Markup Summary **Plat**

ENG-SF19004-R2-LOI-Redlines_Summary

ENG-SF19004-R2-FDR-Redlines_Summary

Markup Summary CDs

24" OUTFALL INTO SAND CREEK
1"=5'

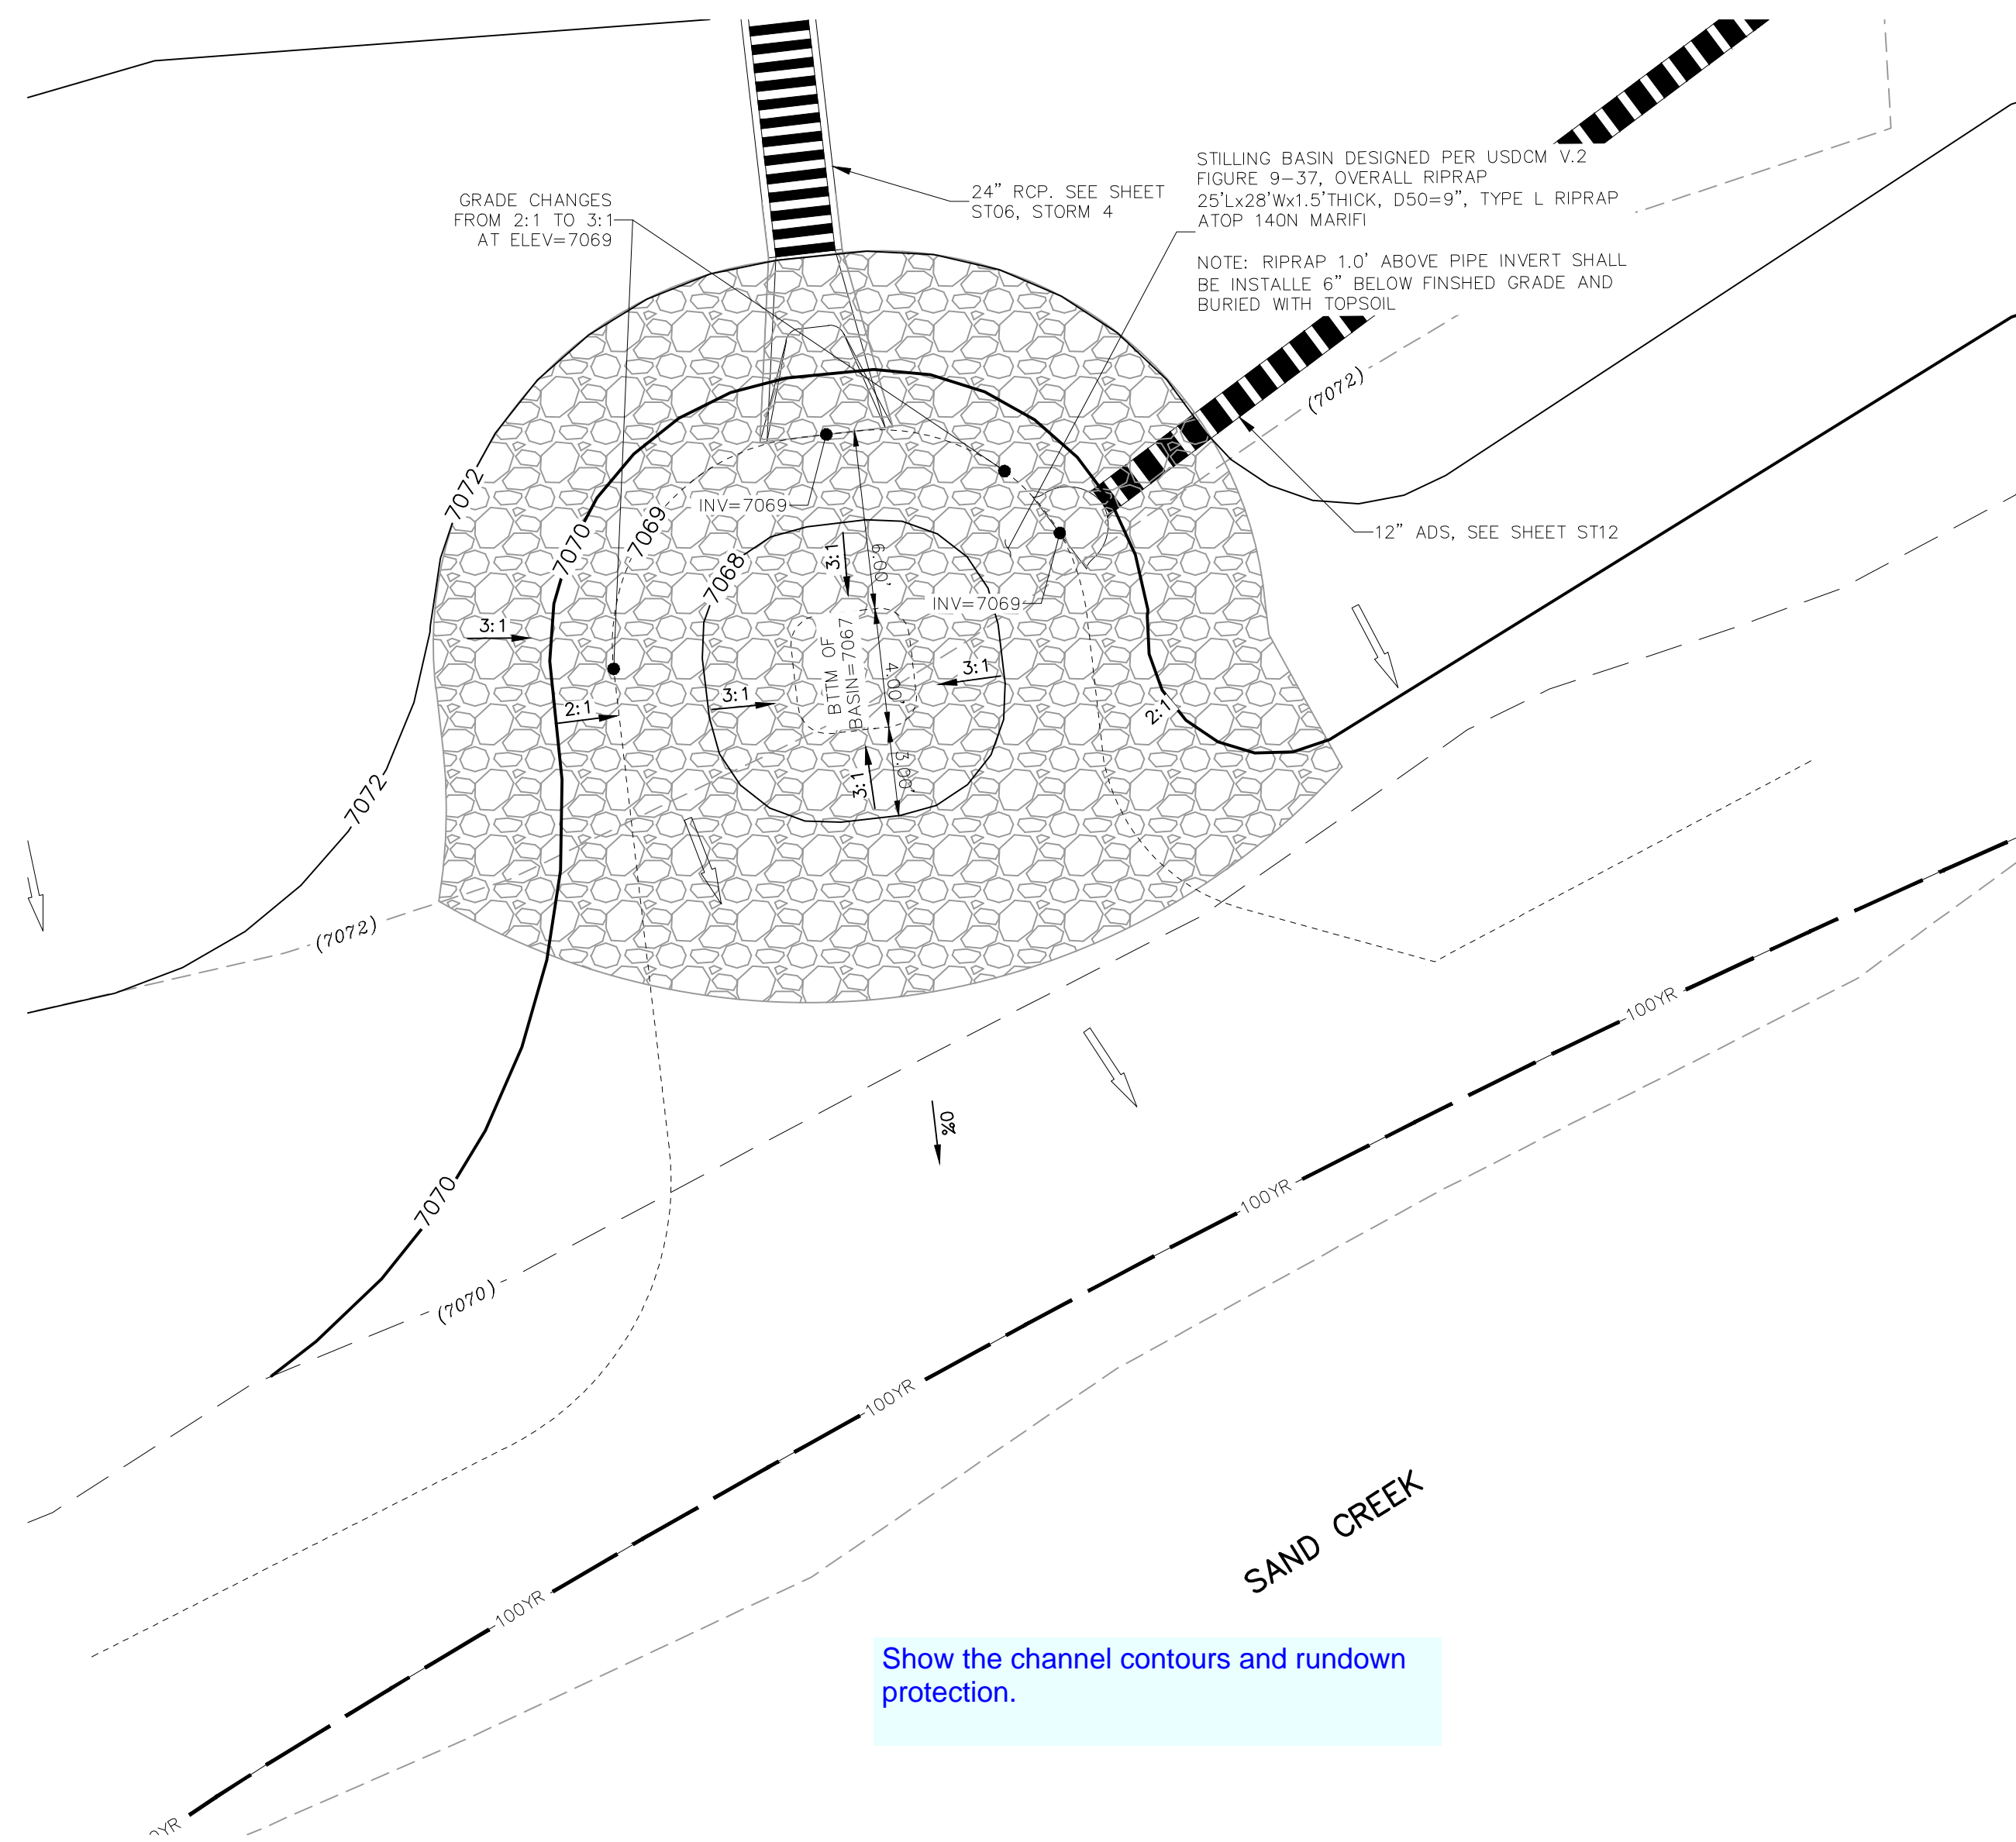
Show the channel contours and rundown protection.

Show channel contours and rundown protection.

**CUT BANK DRIVE
 STA 1+54.86 TO STA 14+50.00**

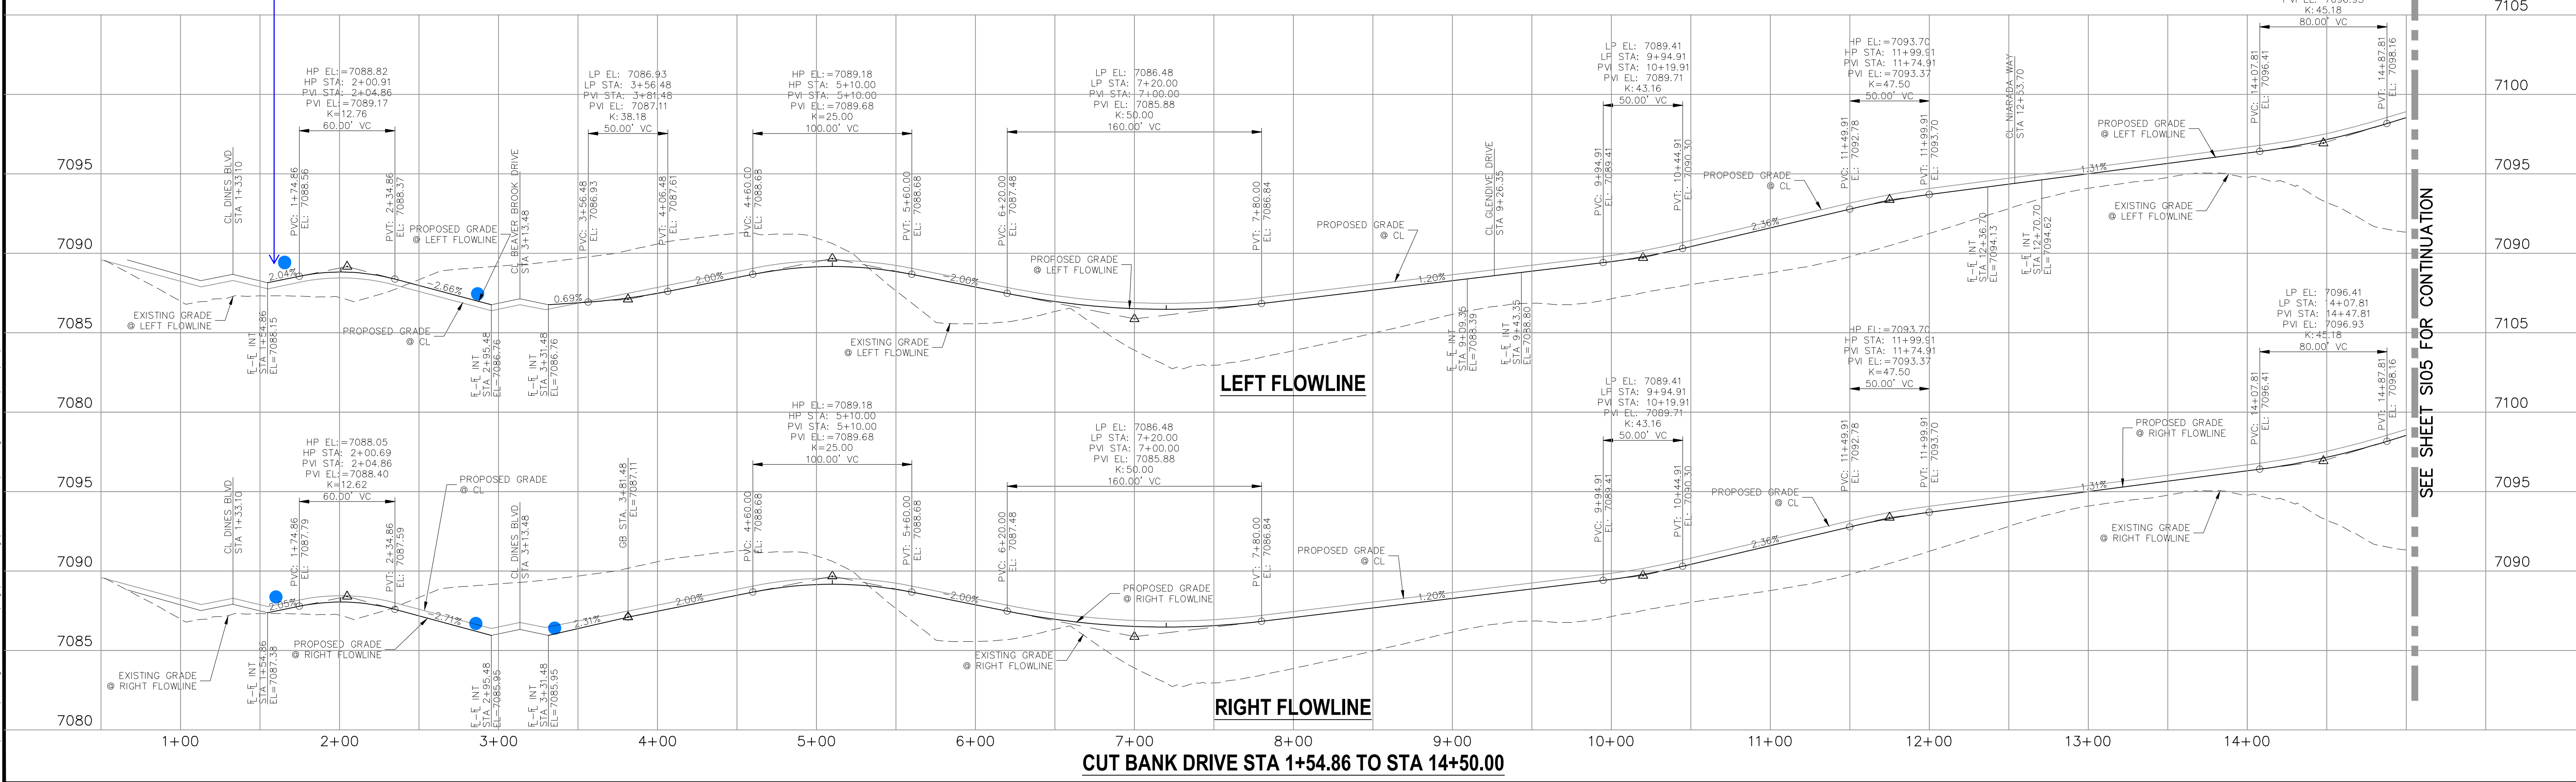
Ensure that pedestrian access routes meet ADA requirements at all intersections. See comment letter.

BEAVER BROOK DRIVE CUL-DE-SAC 2 STA 0+00.00 TO STA 2+76.97

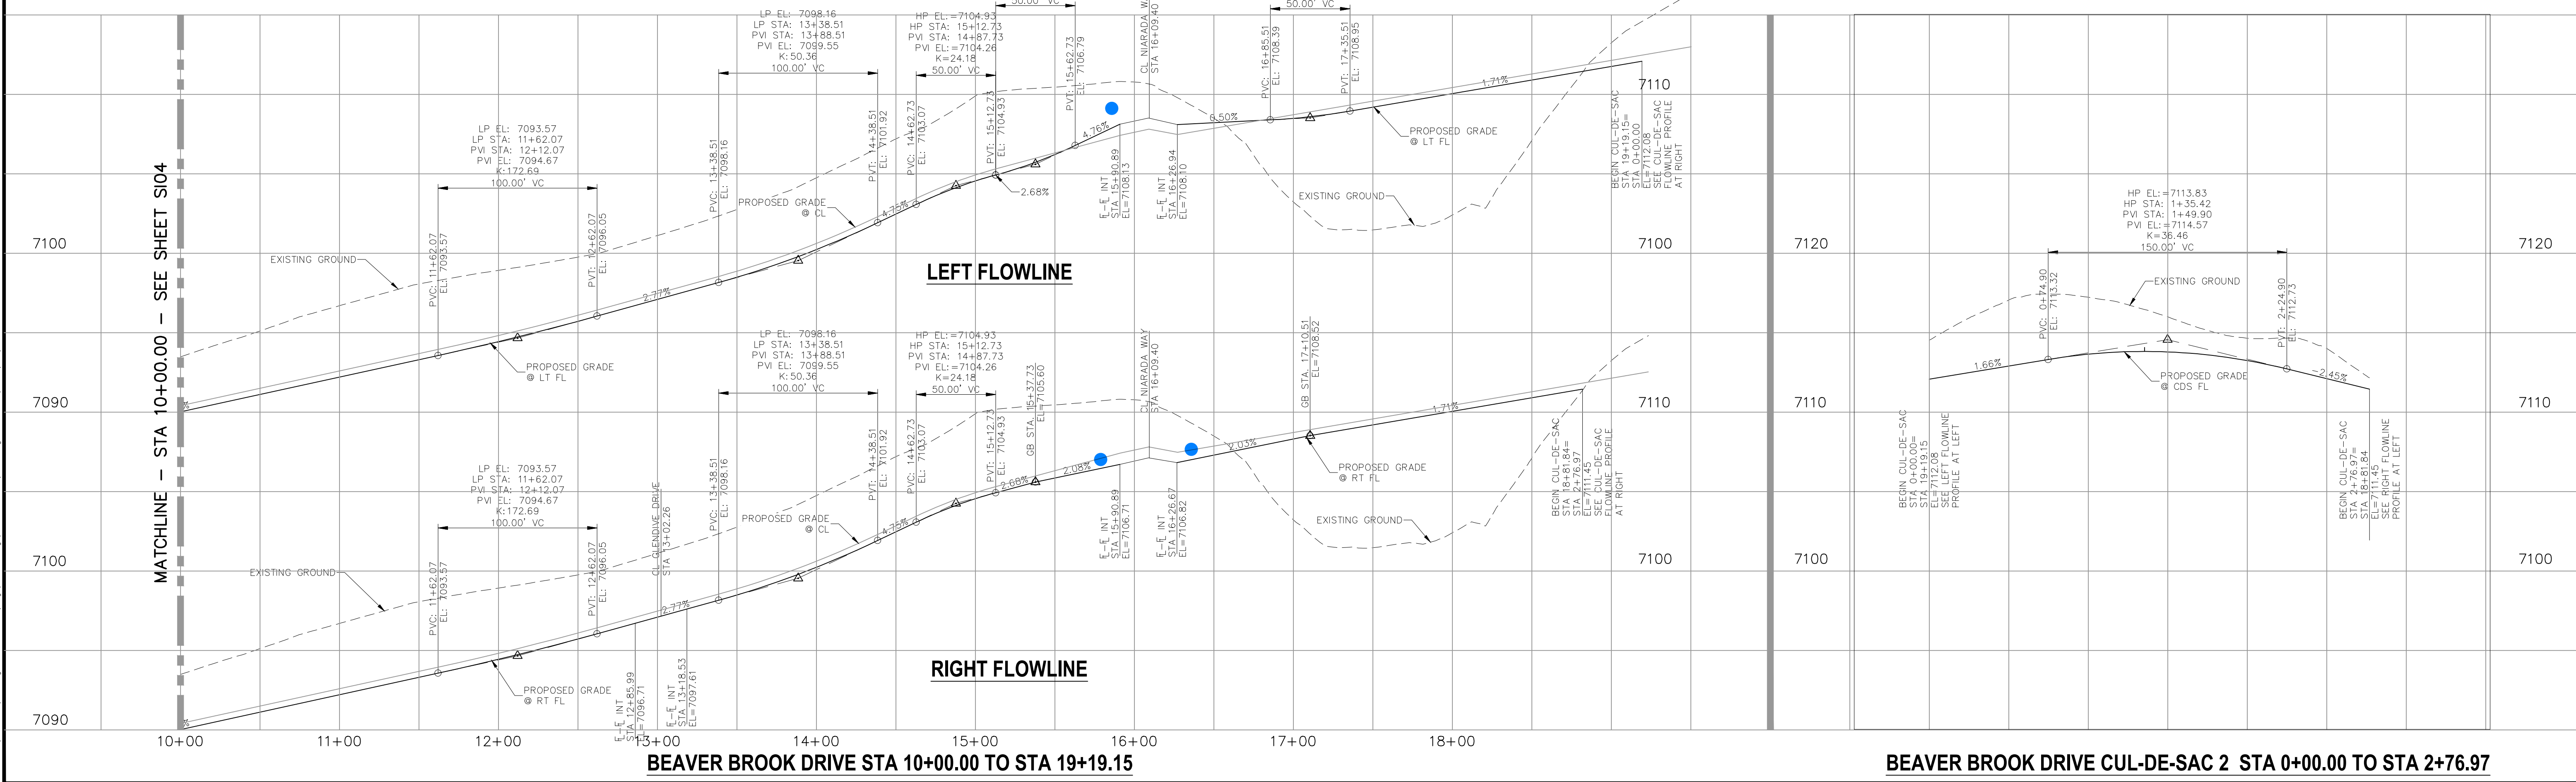
Label cul-de-sac slope and cross-slopes.

Label cul-de-sac slope and cross-slopes.

Label cul-de-sac slope and cross-slopes.

TRACT 'C'
STERLING RANCH
FUTURE
COMMERCIAL

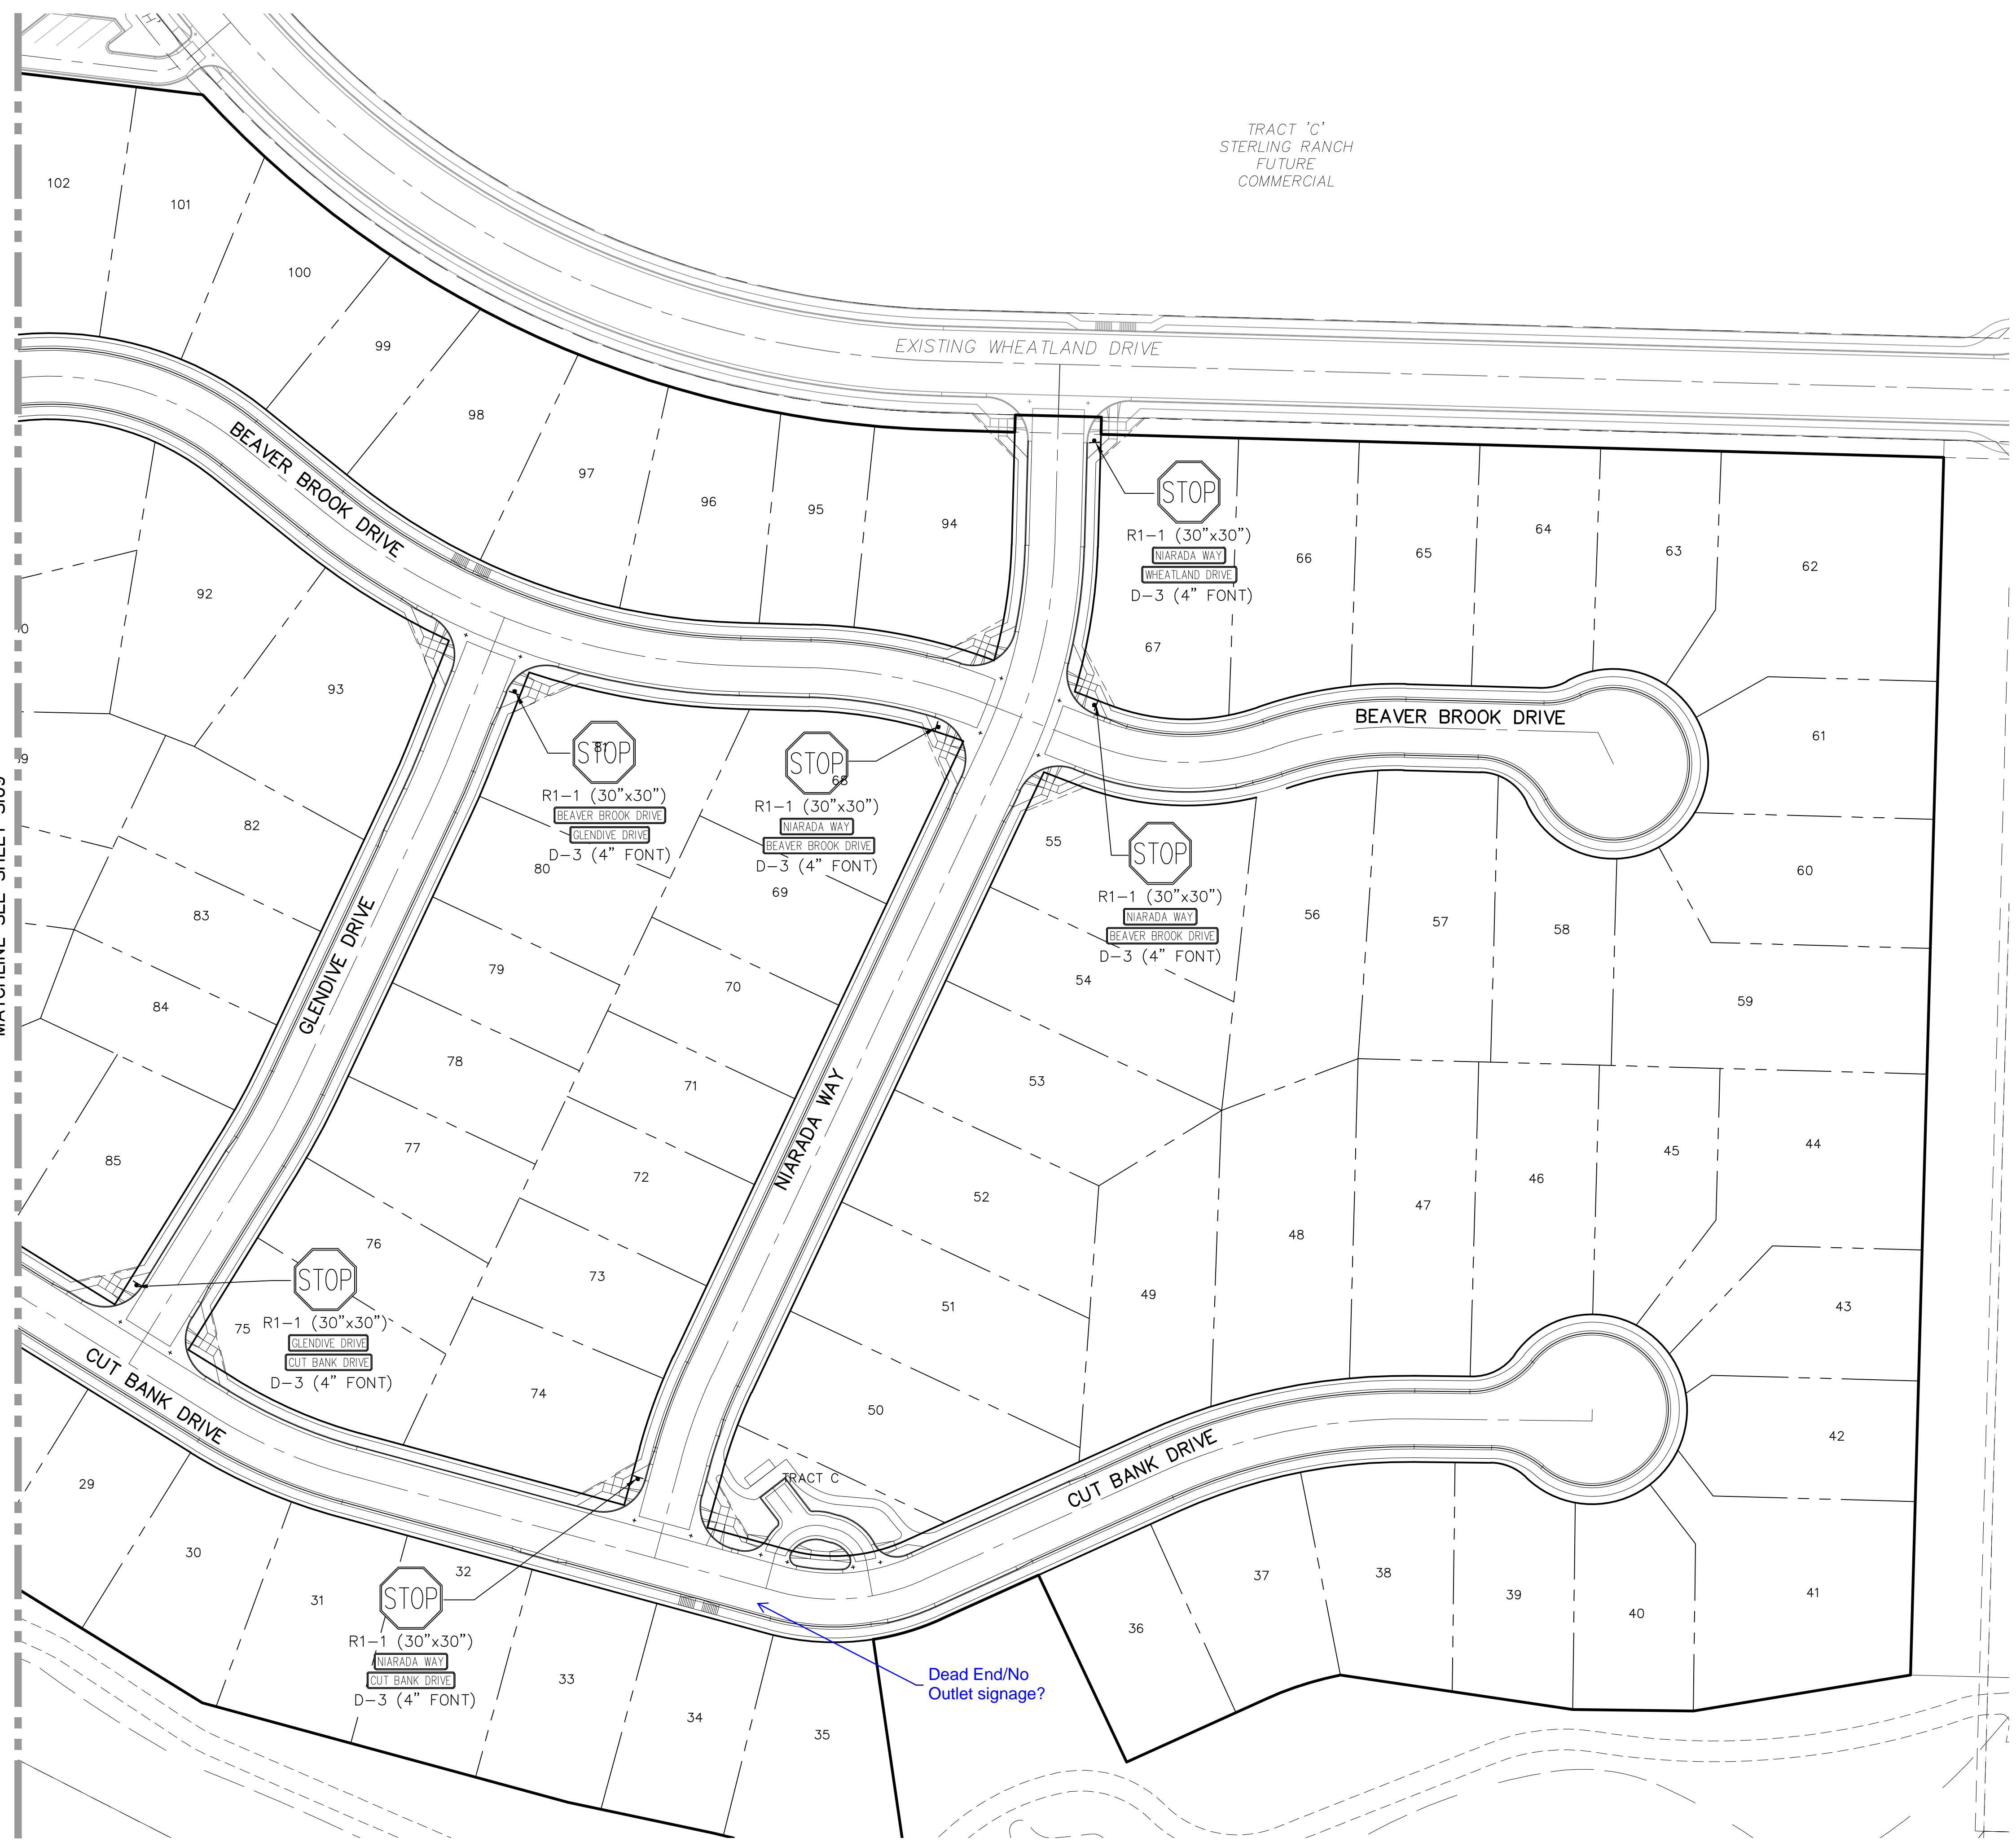
Dead End/No Outlet signage?

Dead End/No Outlet signage?
